Our Ref: WA/4/19/HH

**Town & Country Planning Act 1990 (as amended)
Town & country Planning (Development Management Procedure) (England) Order 2015
Application for Planning Permission for Works or Extension to a Dwelling**

Development Retrospective approval for variations to approved (ref.WA/22/07/) detached garage / store to form detached garage / annexe.

Location Ashogle Eastergate Lane Walberton

APPROVED

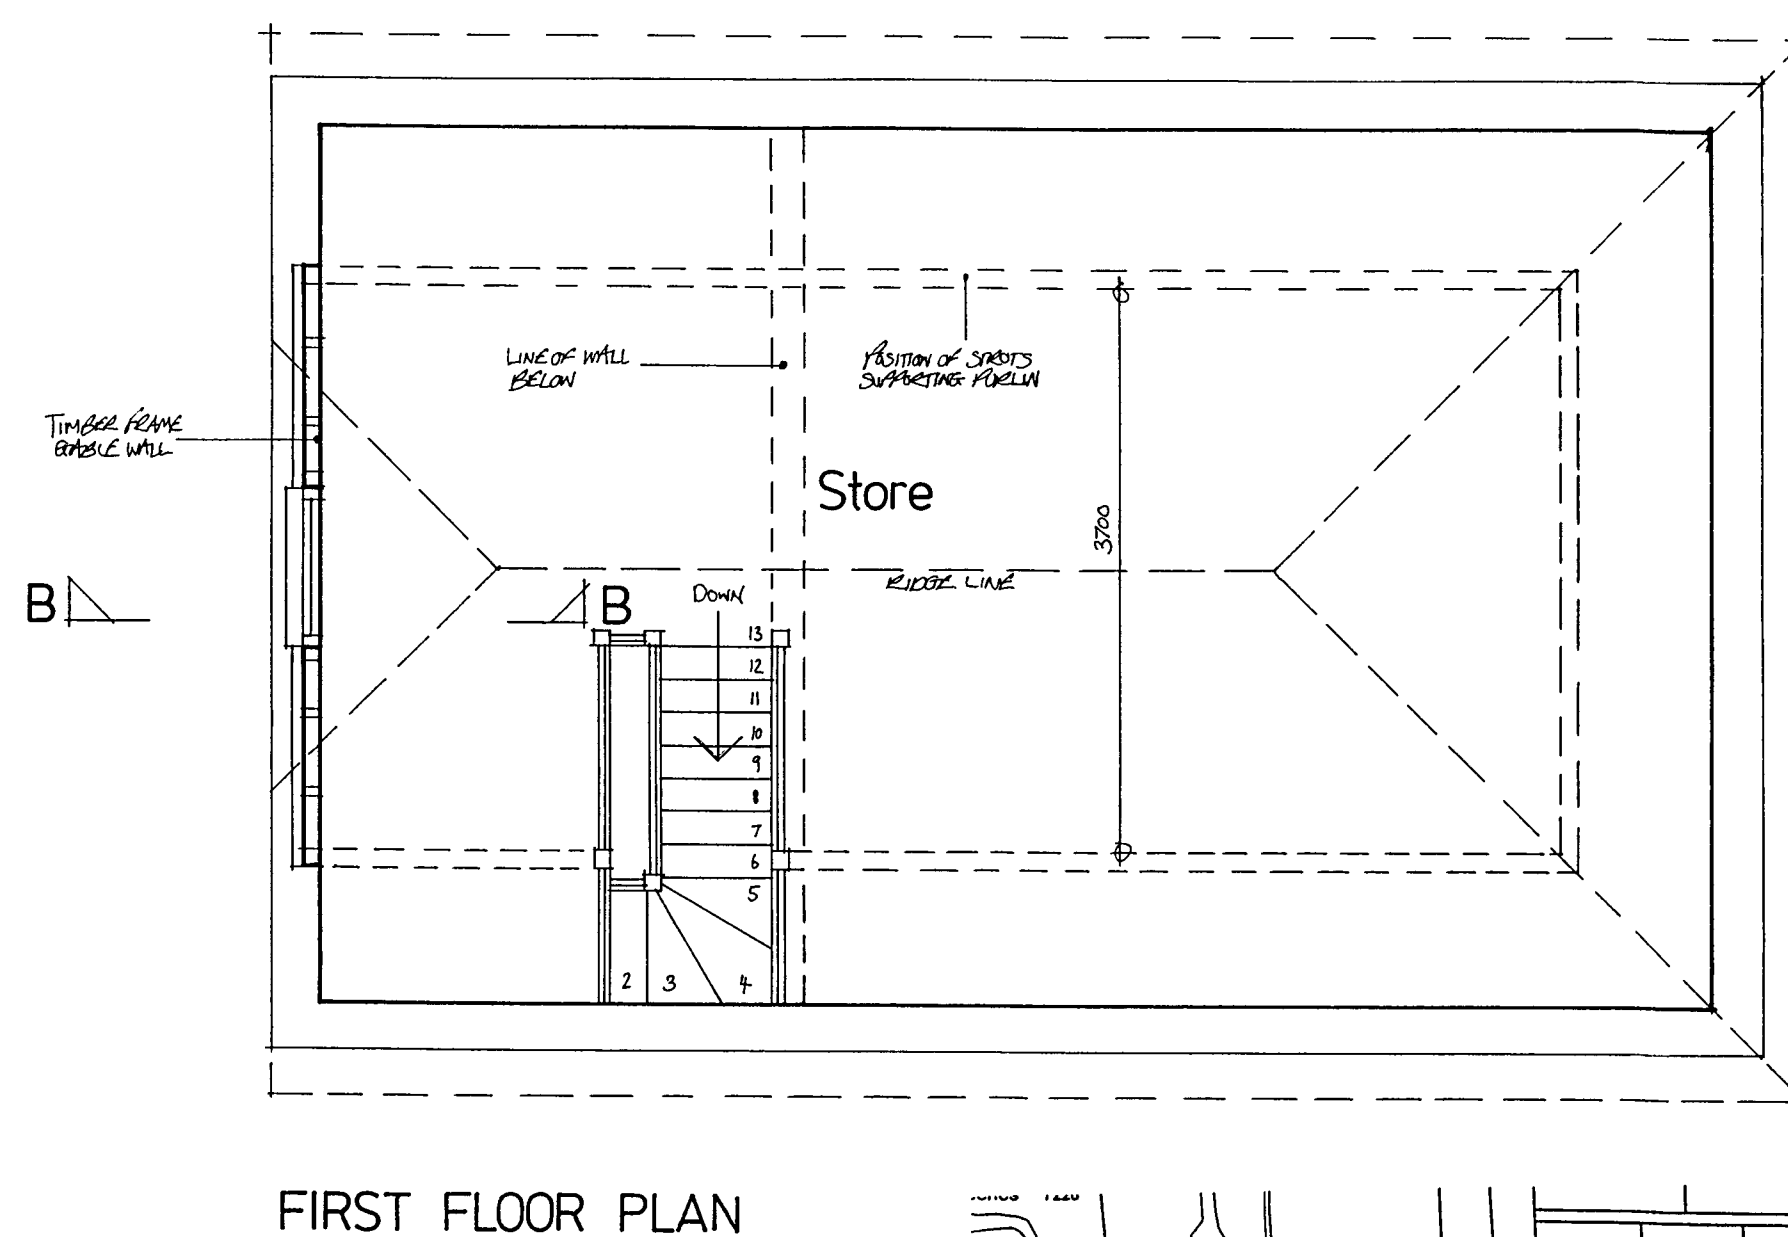
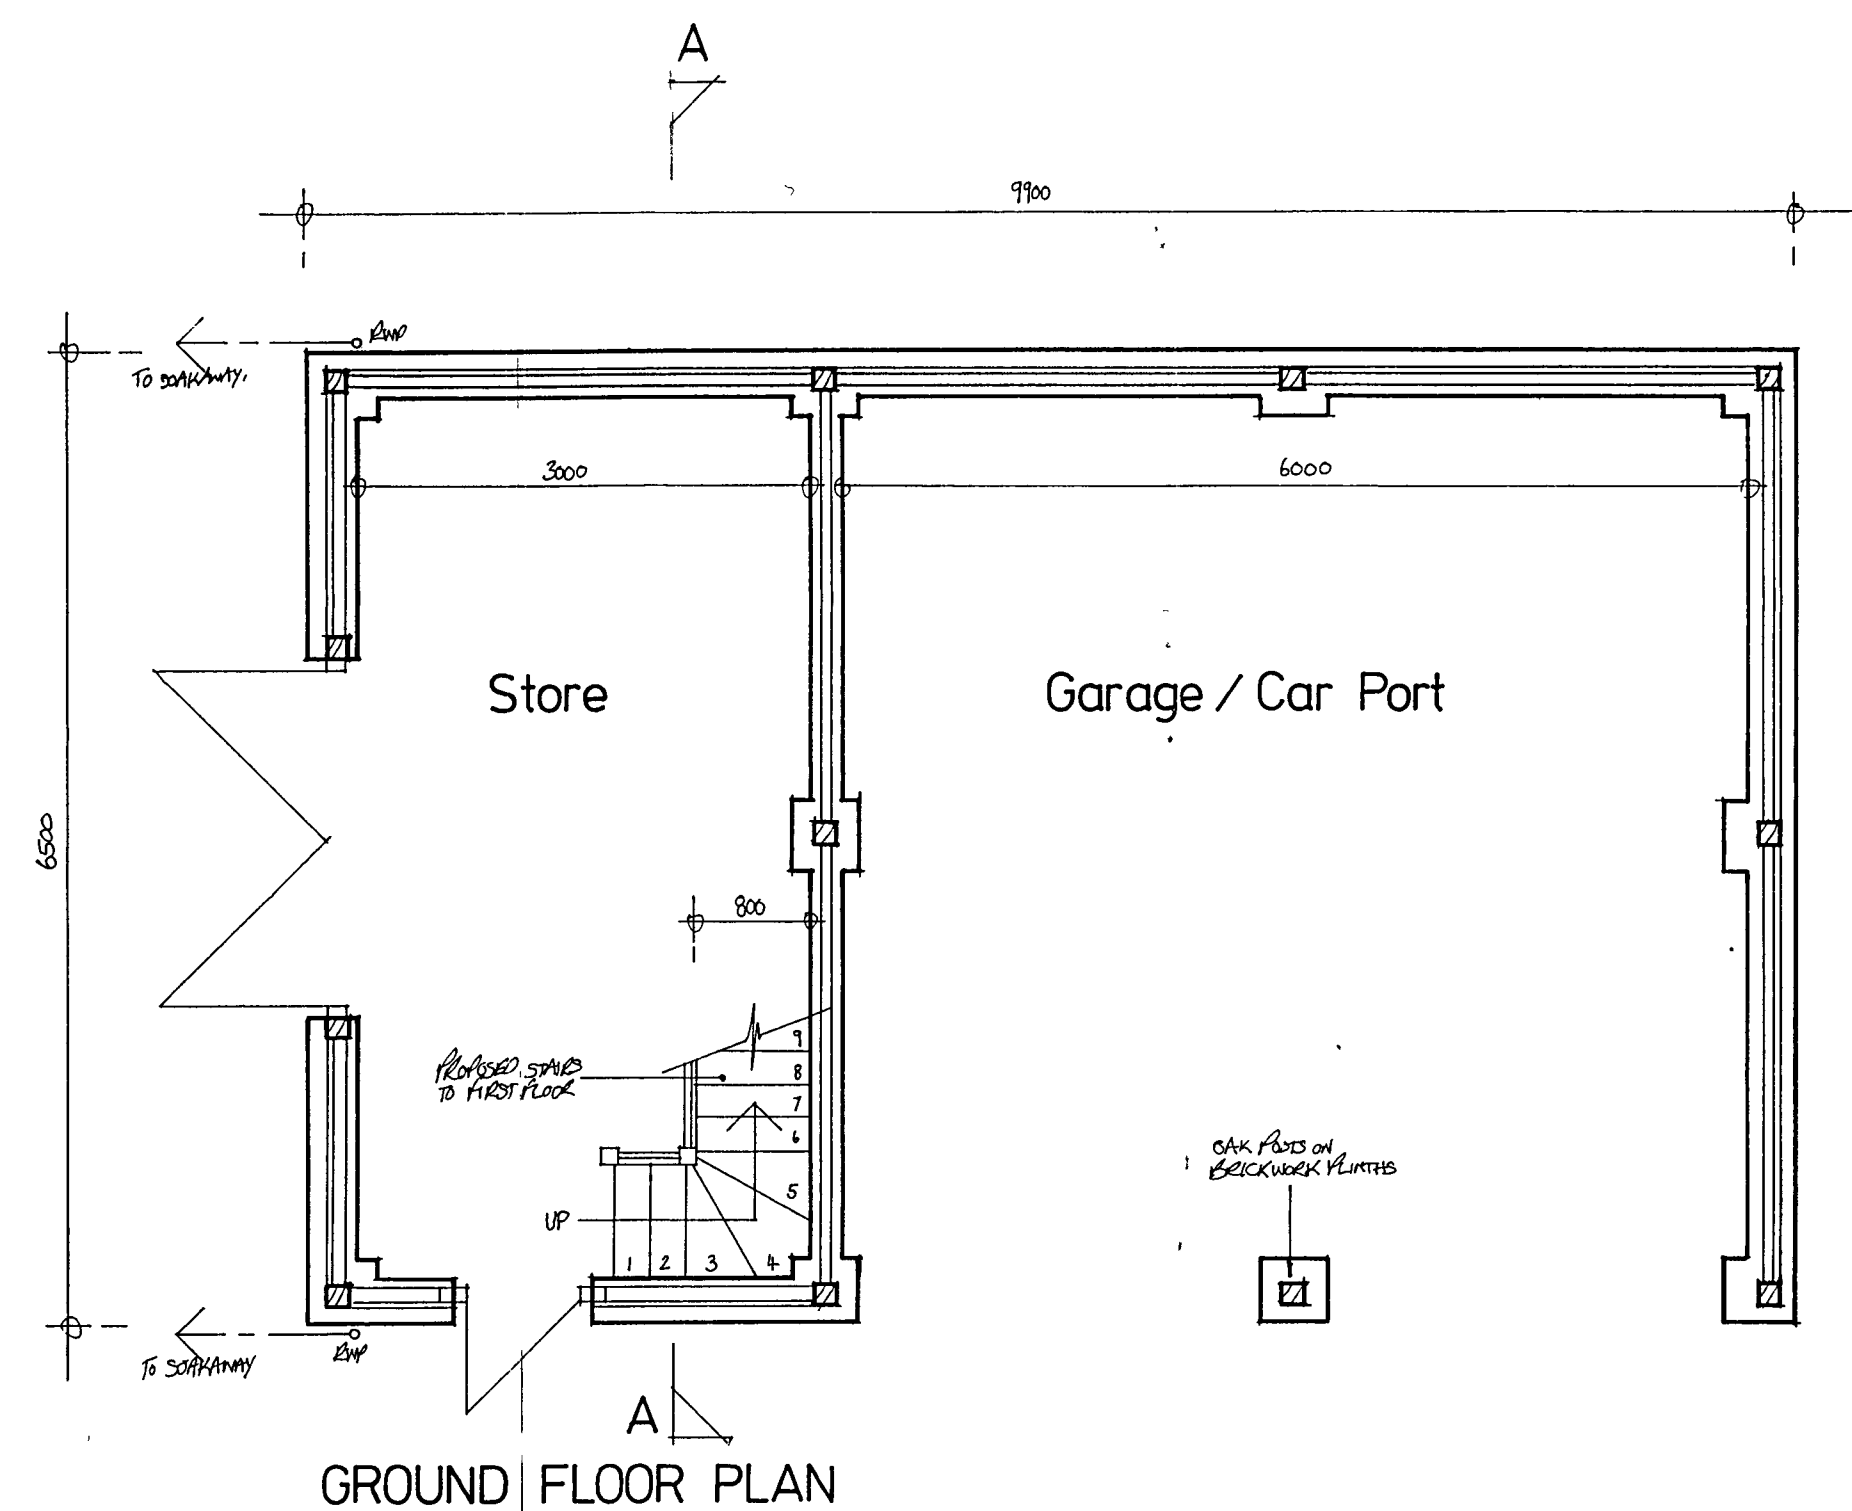
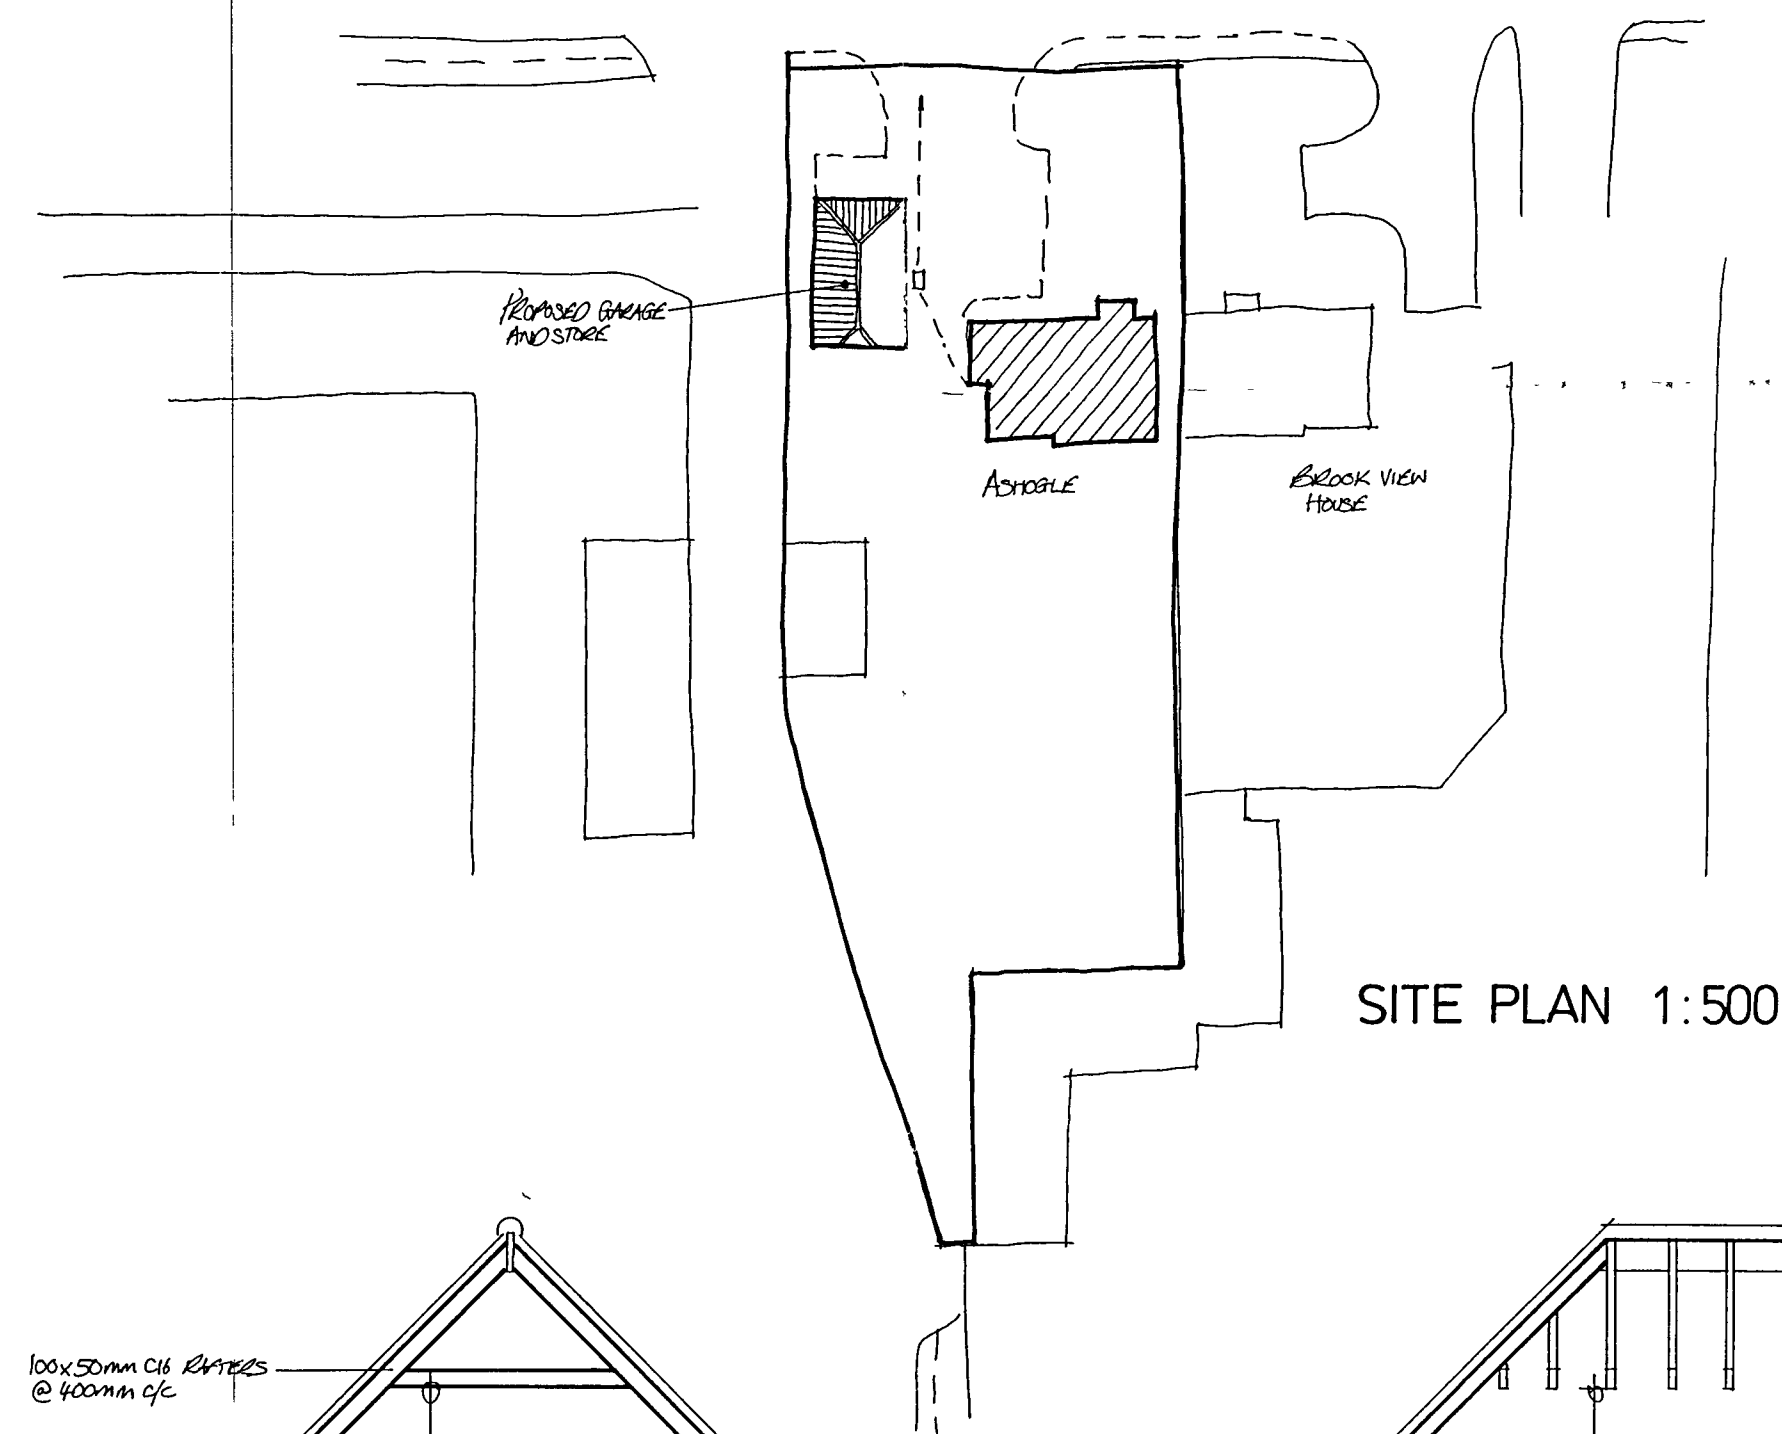
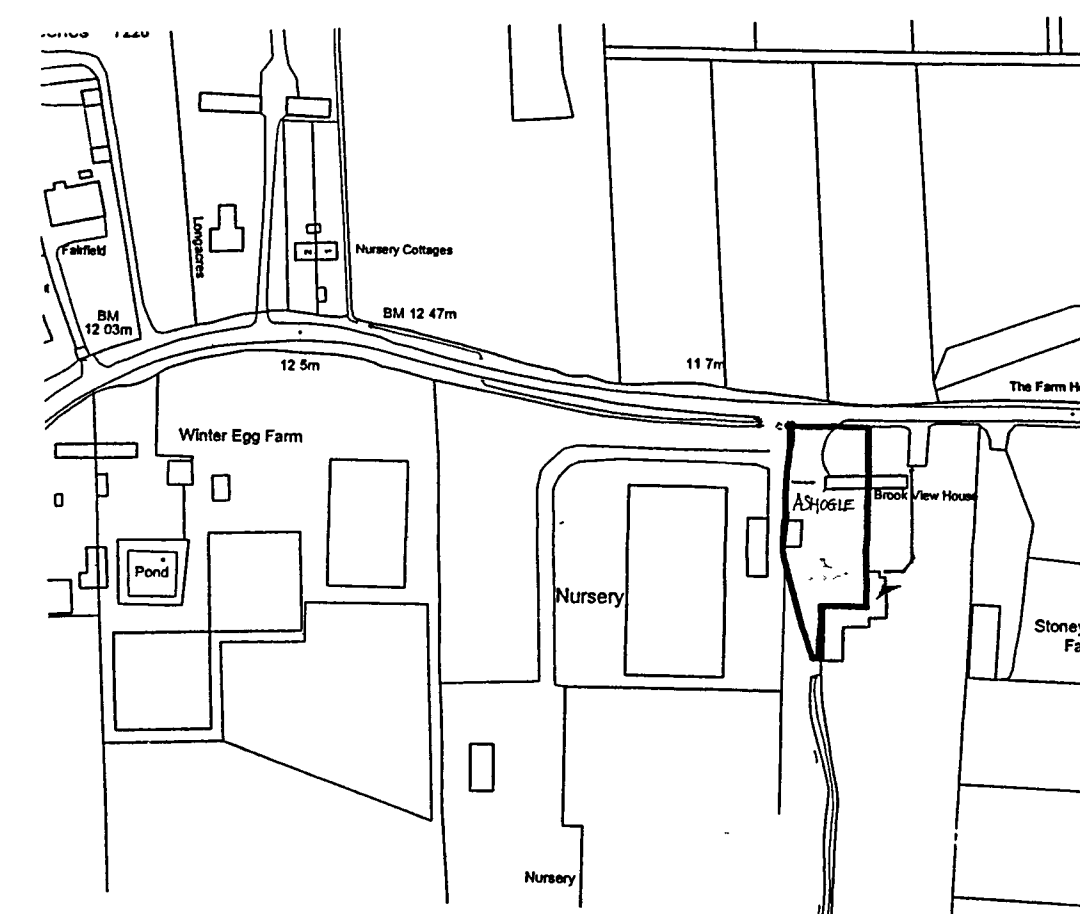
Approved Plan: Please label the approved plan as approved on the actual plan rather than as the saved file name.
